URBAN DESIGN BRIEF

MARKETPLACE WEST

35 STOREY APARTMENT BUILDING
1034 MCGARRY TERRACE

Stantec has prepared the following response to recommendations received from the Urban Design Review Panel (UDRP) on 19 June 2023 following an informal presentation by the project team on 2 June 2023. Panel comments have been listed in the left column of the table below, whereas the project team’s response is provided in the right column.

8		16	
7		15	
6		14	
5		13	
4		12	
3		11	
2	FEB 27.24	10	PHASE 2 PRE-CONSULT.
1	DEC 21.23	9	RE-ZONING
rev.	date	issued for	date issued for

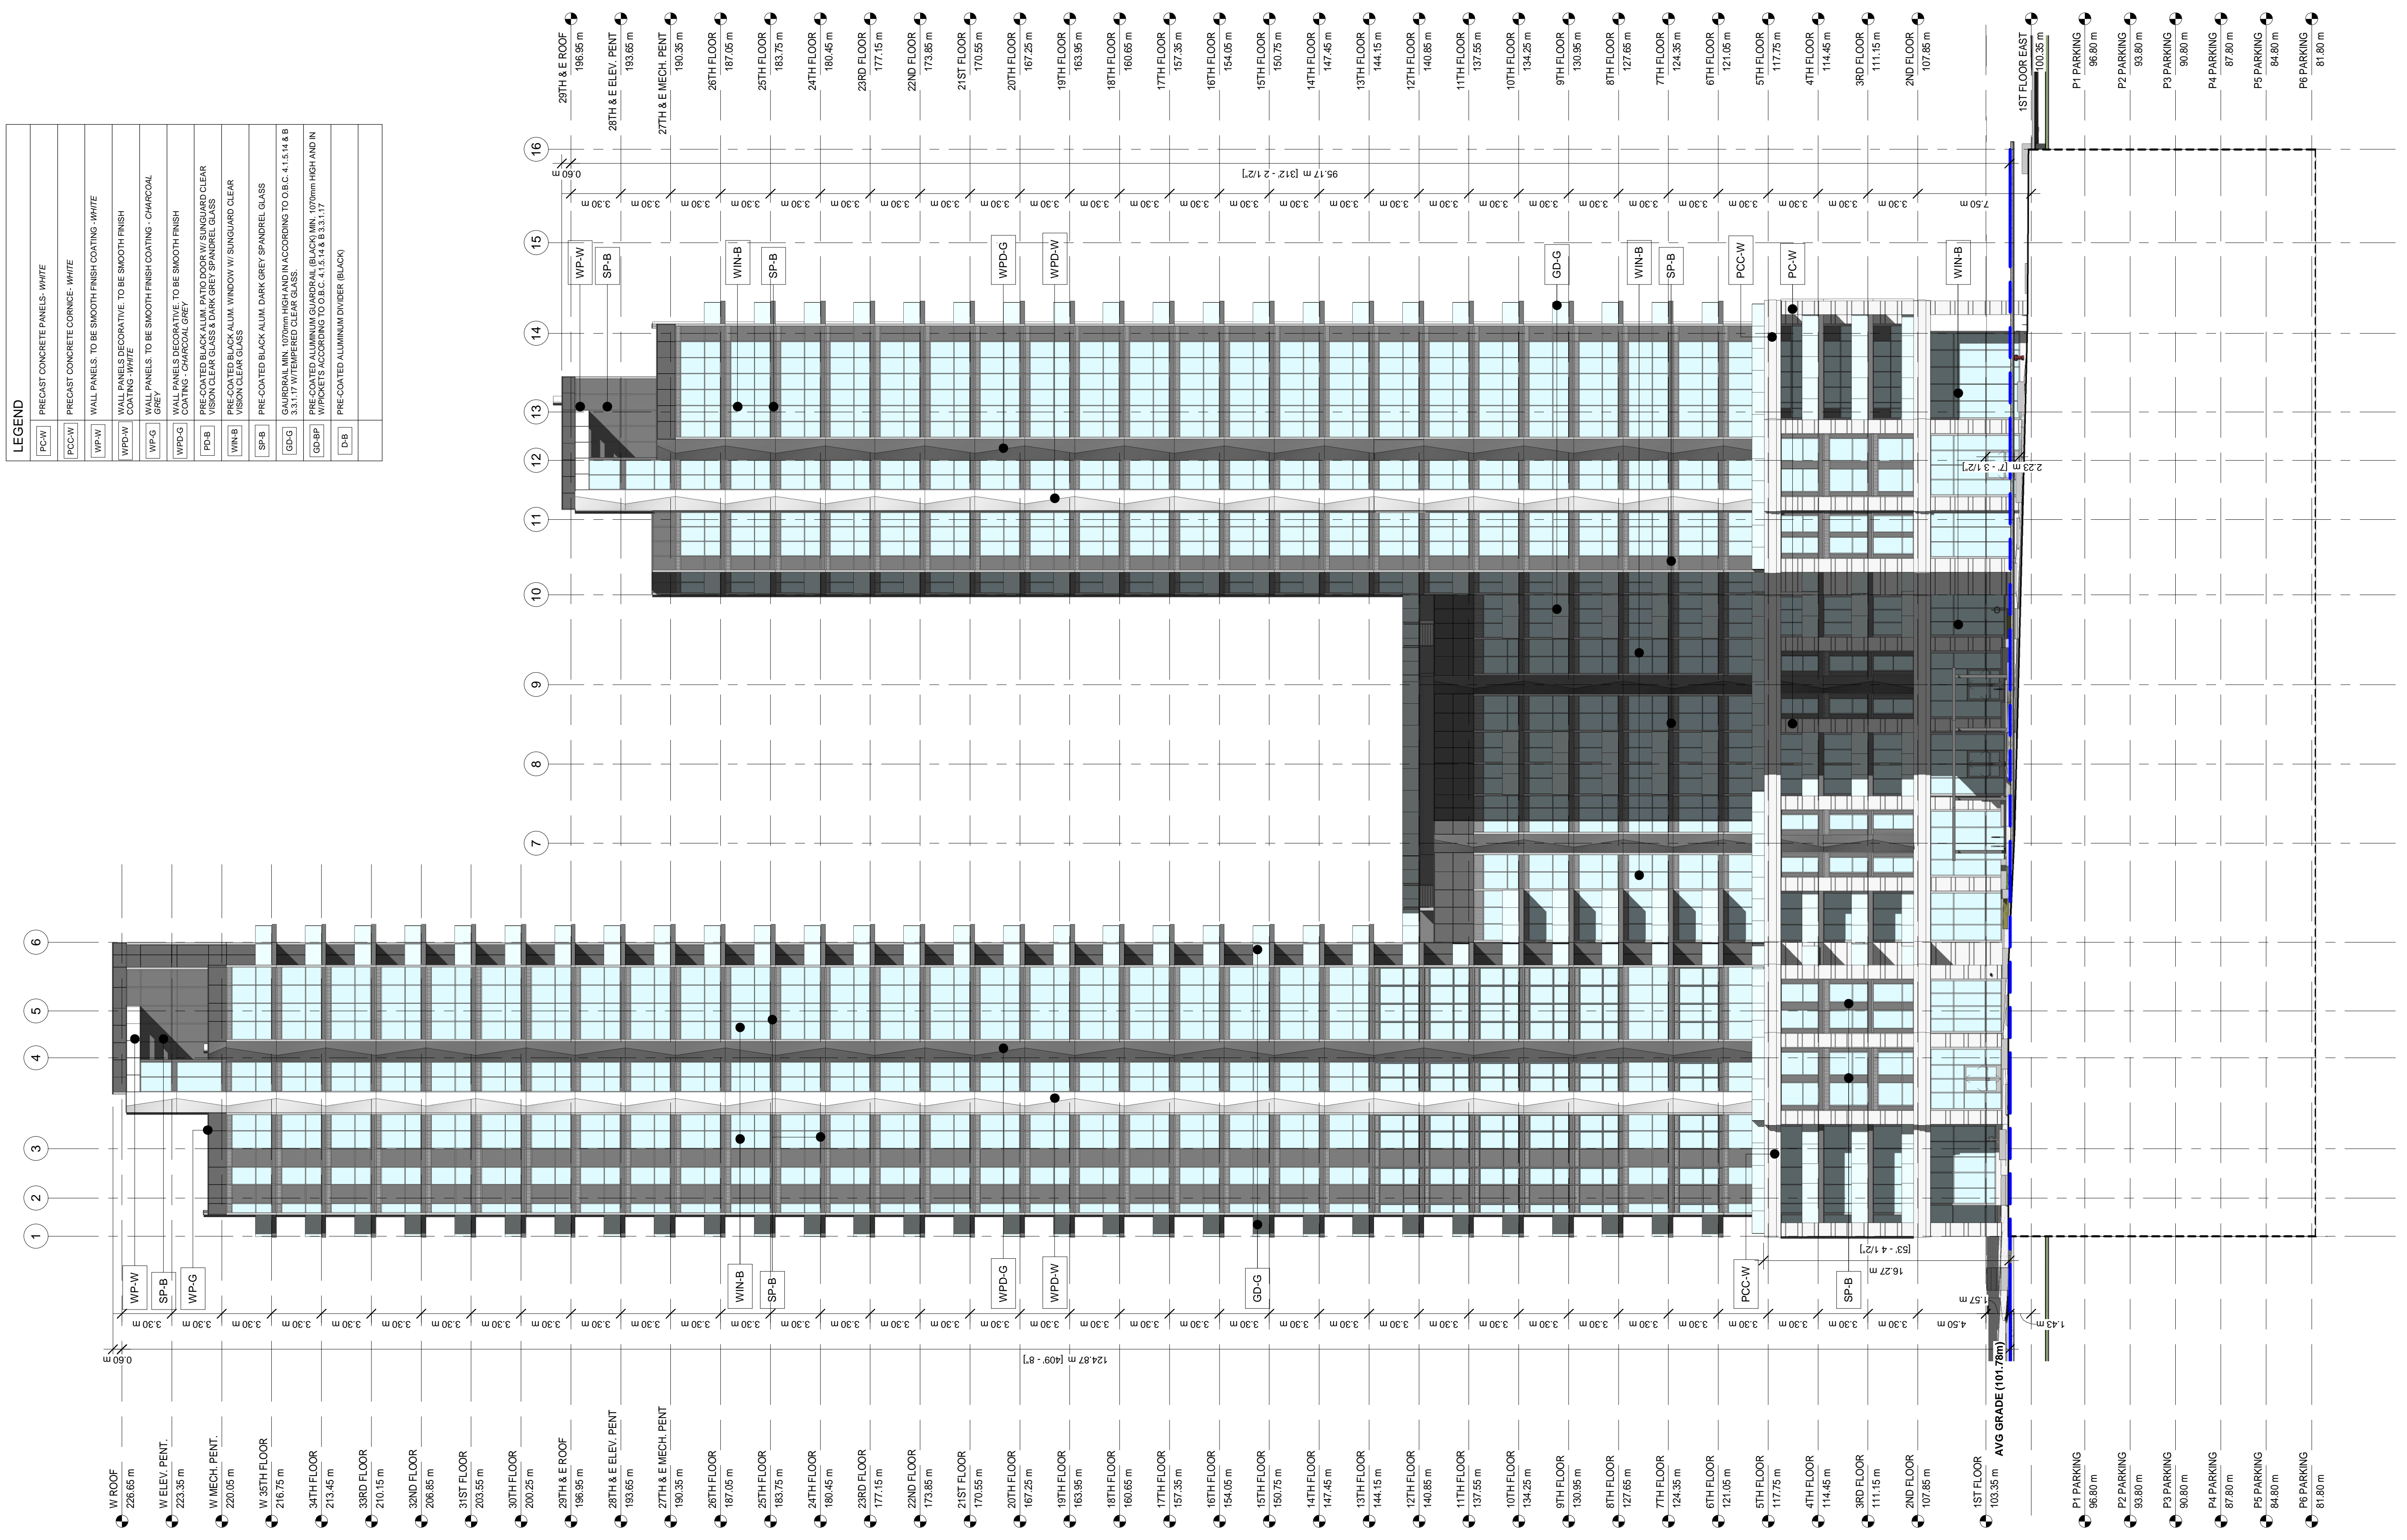
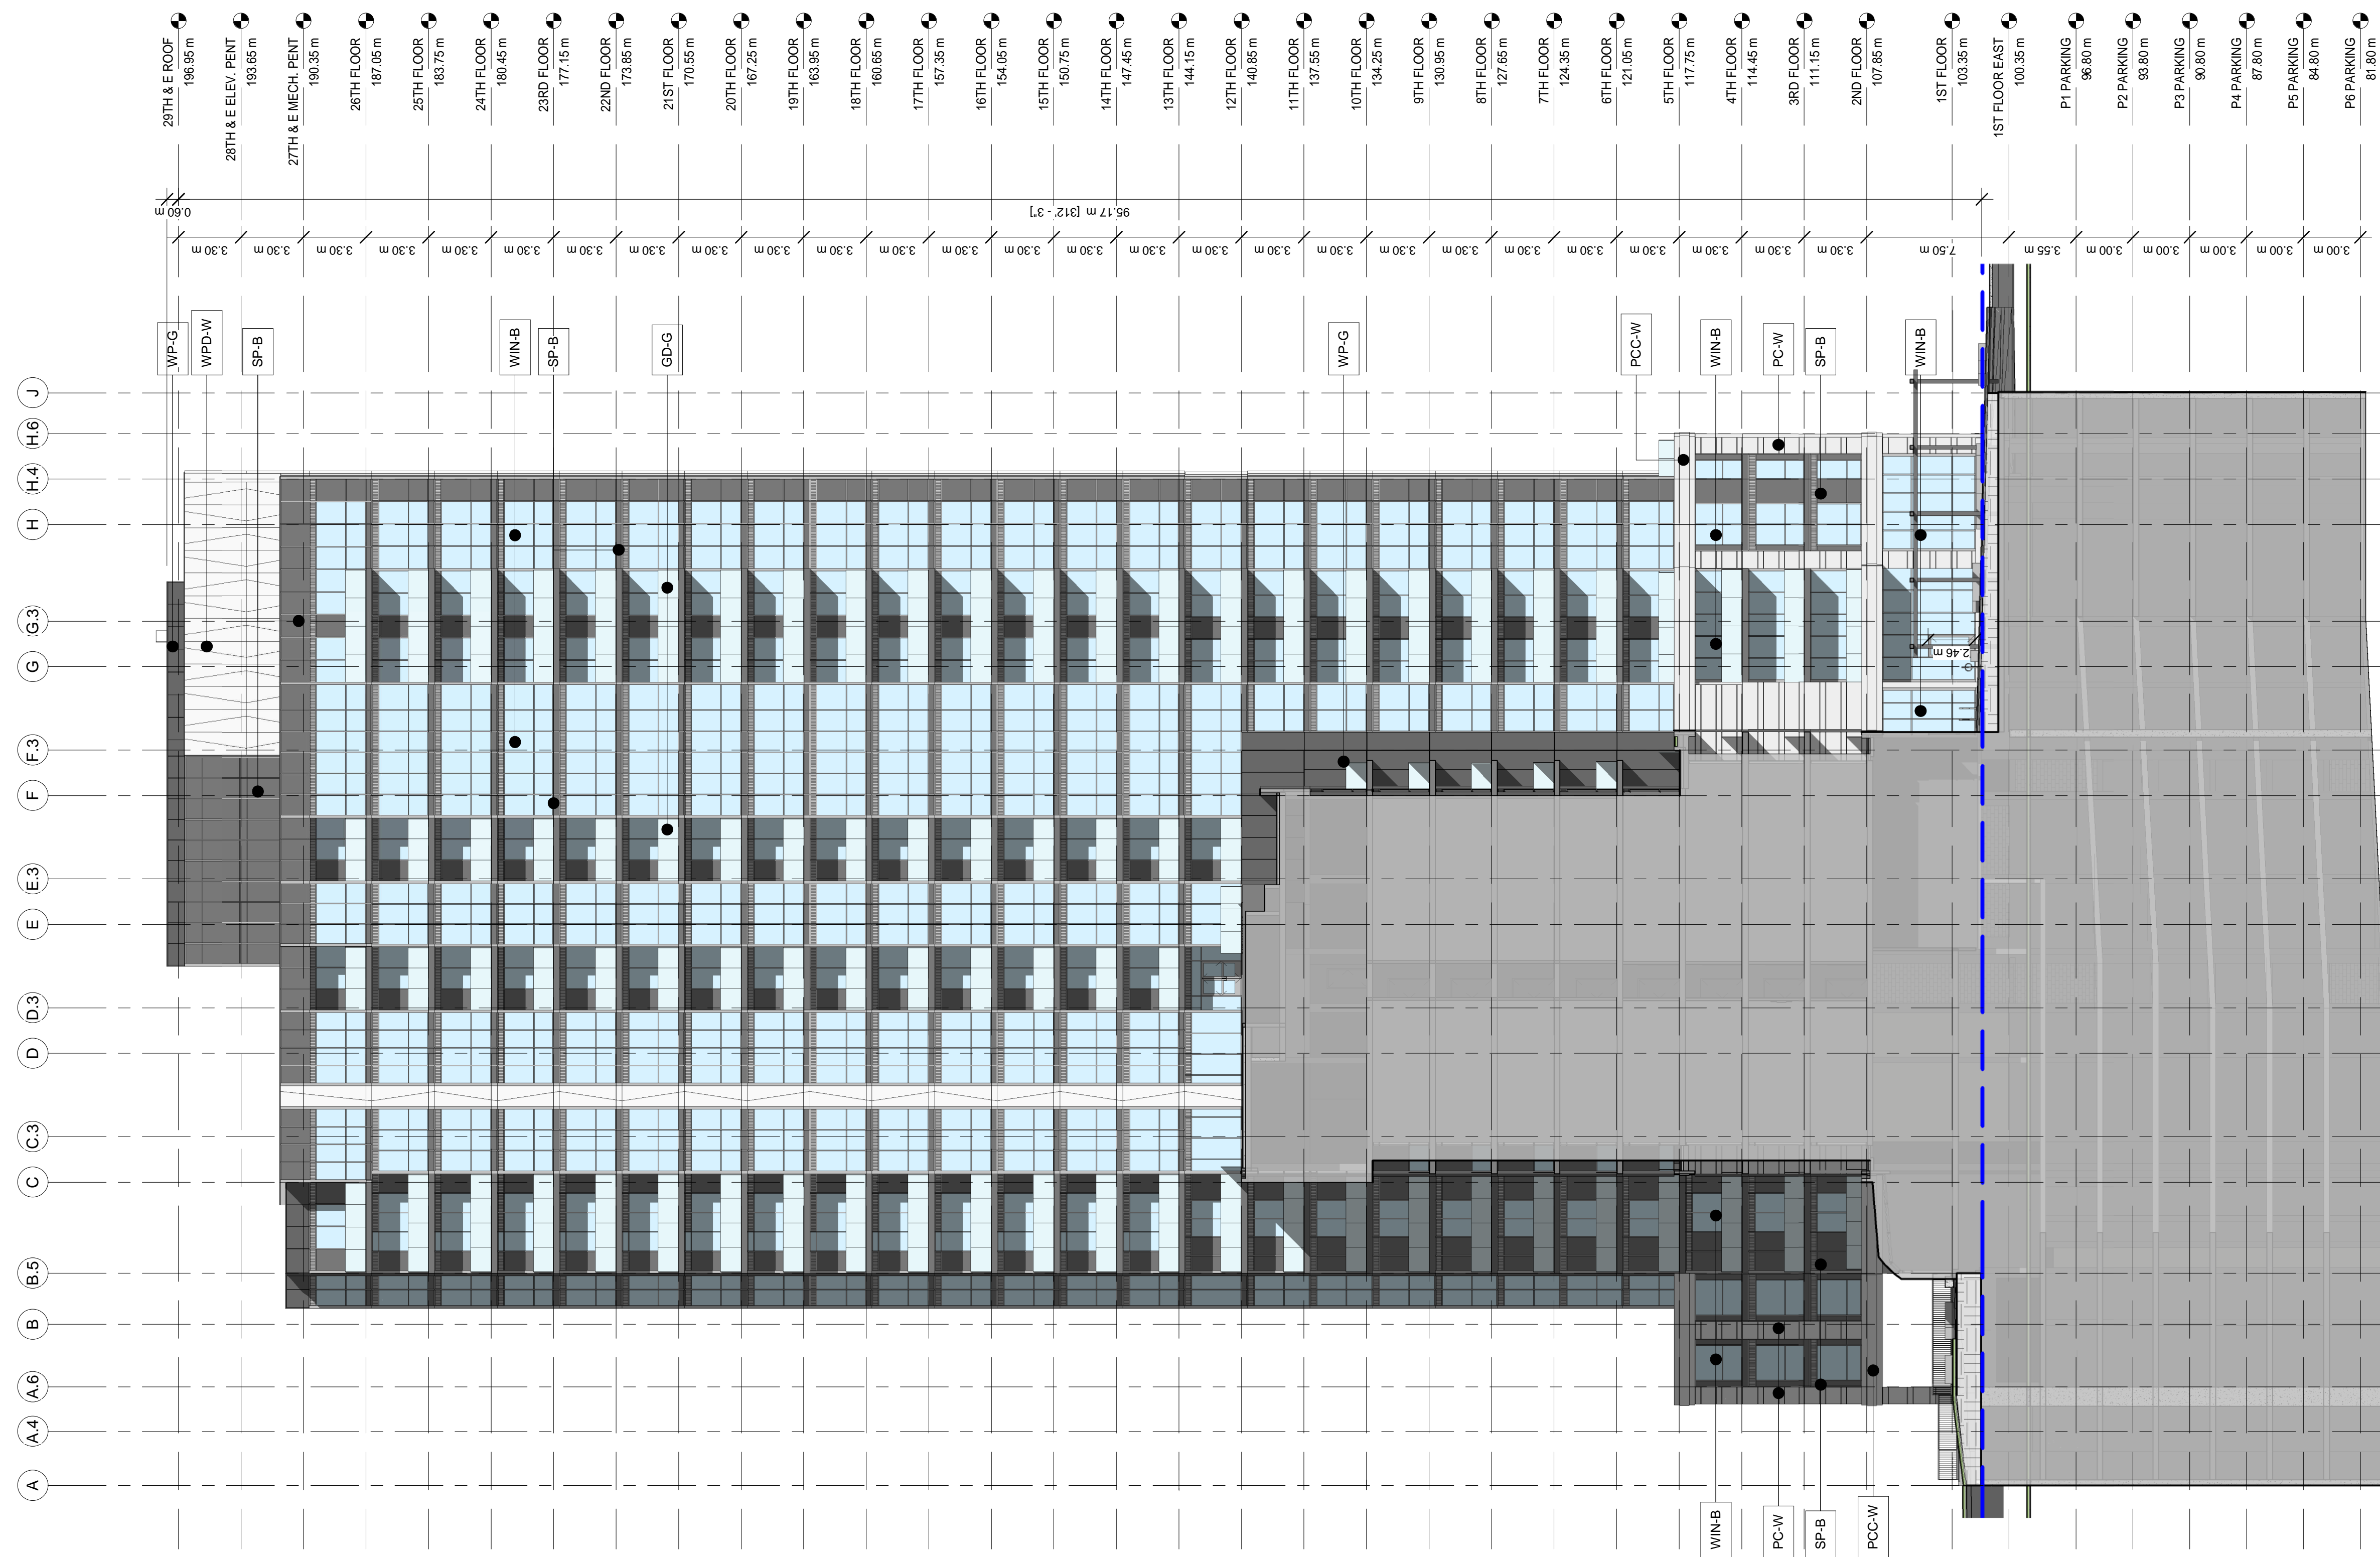
The Panel recommends stepping the towers back considerably along the street frontages

- Consider a minimum 3 metre step-back above the 4-storey podium
- Consider additional step-backs up the tower.

The Panel recommends staggering the heights of the towers to a more appropriate scale and transition from the surrounding context.

- Consider a 30-storey tower on the west side nearest to McGarry Terrace, and a shorter tower closer to 20-storeys on the east side

Step-backs have been provided from Marketplace Avenue and McGarry Terrace. Tower floorplates have been reduced to the extent feasible to increase tower separation distances and increase step-backs.

To ensure that there is variation in height between the two towers, it is proposed that the west tower be reduced to 35 storeys in height, whereas the east tower would be reduced to 26 storeys.
